**Revised Planning Proposals - Outbuilding**

Design Statement in Supporting Adjustments to Consented Scheme

**Glenlossie, Mill Road**

Project Name: Glenlossie, Mill Road Debden,  
Saffron Walden, Essex CB11 3LB  
Planning Ref.: UTT/22/0342/HHF  
Subject: Revised Planning Proposals - Outbuilding

Drawing No	Rev
2019-AR-07-201	-

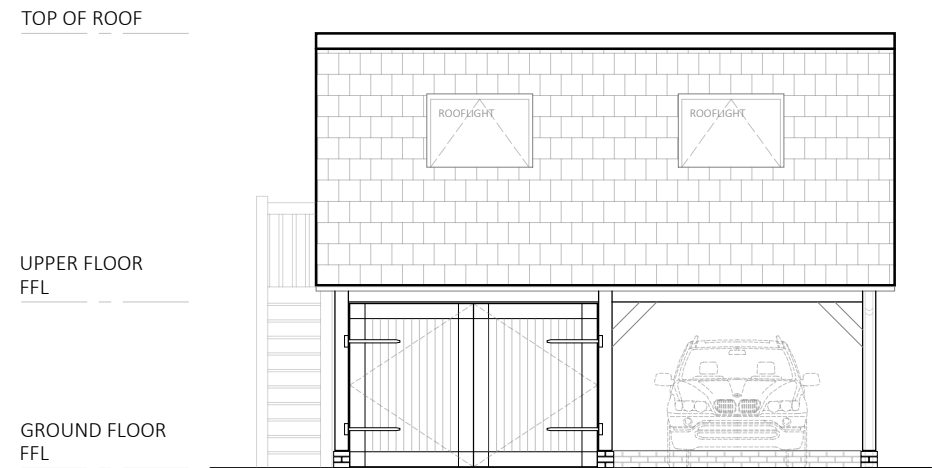
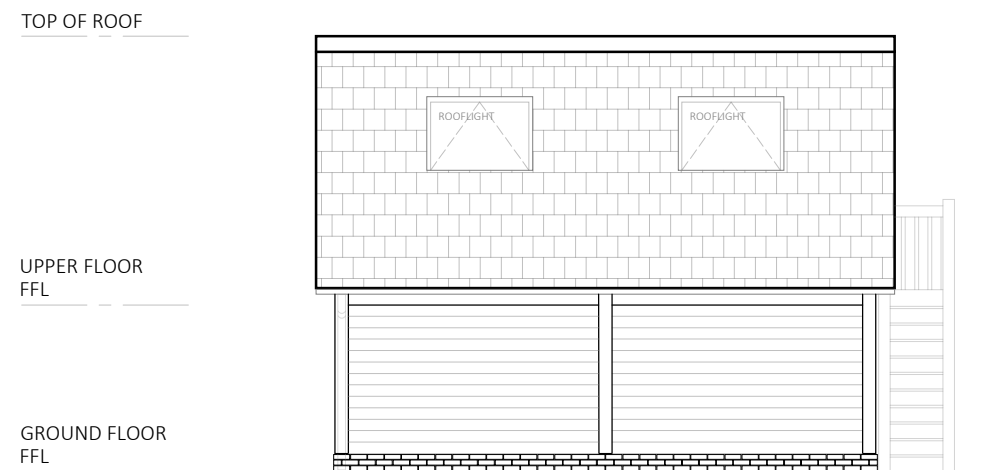
Revisions to the original consented proposal are shown on drawing numbers 2019-AR-07-200 (see page 16) and 2019-AR-07-201 (see page 17). Red lining on both drawings shows an overall reduction in the footprint of the garage block with a slight increased ridge level (750 mm) over that of the original proposal. The increase in ridge level is designed to facilitate the introduction of a home office/studio space, which will be accessed by an open stair on the north side of the building.

While the proposed ridge level increases by 750 mm the overall bulk of the outbuilding has decreased by 5%.

The originally proposed materials for walls and roof remain unaltered. The main adjustment at roof level centres on the incorporation of 4No Velux or equal roof lights. Given the location and size of trees surrounding the Garage/Outbuilding Block, there will be no overlooking issues associated with these roof lights on the east and west elevation.

Originally a window was incorporated on the east elevation to provide natural light to the storage building. It is proposed that this window be removed, and a new window installed on the south side gable to provide a visual link with the residential home at Glenlossie.

Access to the upper floor is via an external stair on the north elevation, which will be constructed in timber.

DRAWING NUMBER LTD175.012

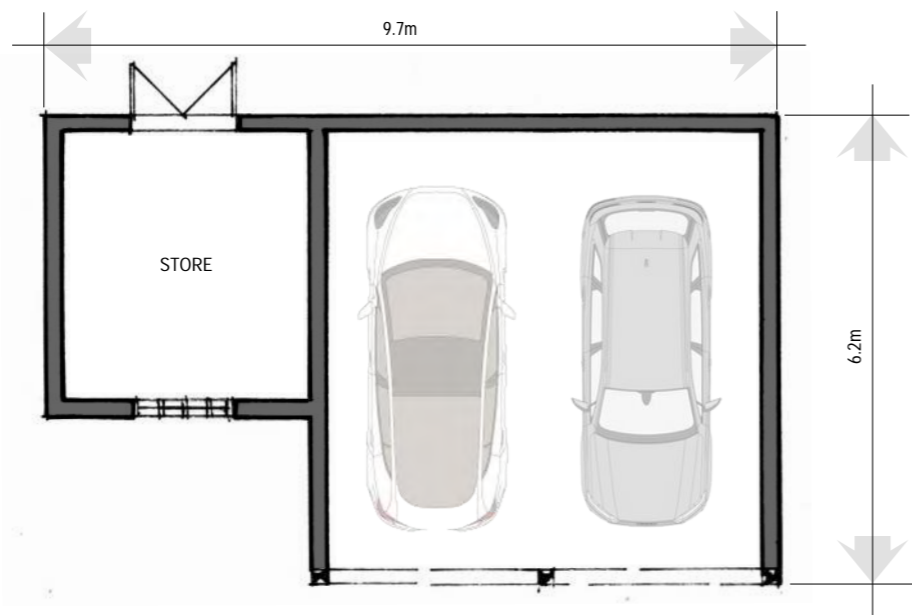
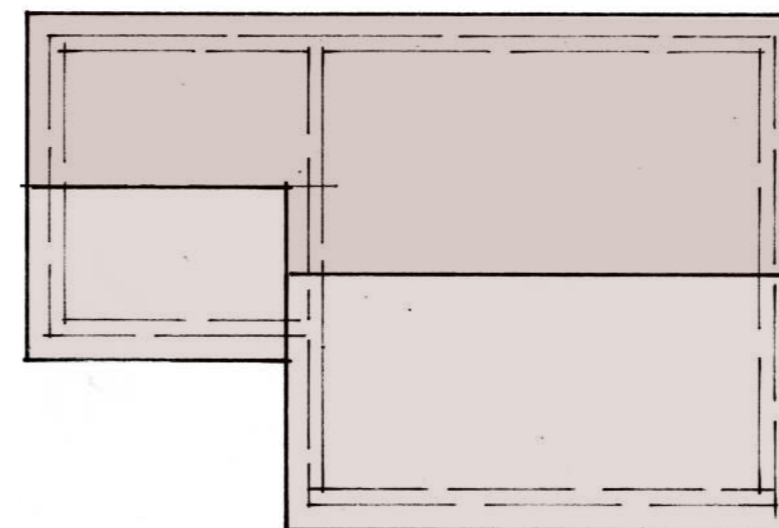
The redevelopment of an existing, but distressed garage block formed part of the Planning Permission granted in respect of application Reference UTT/22/0342/HHF. The documentation associated with the Proposed Outbuilding was shown on drawing reference LDT175.012 (see page 7).

The original proposal (see page 7) showed an overall footprint of 53.4 m<sup>2</sup> and a height to the upper ridge of 5.0 m.

The original roof void was insufficient in height to support a capillary usage other than storage (assuming that roof joists would have been installed to support a storage facility).
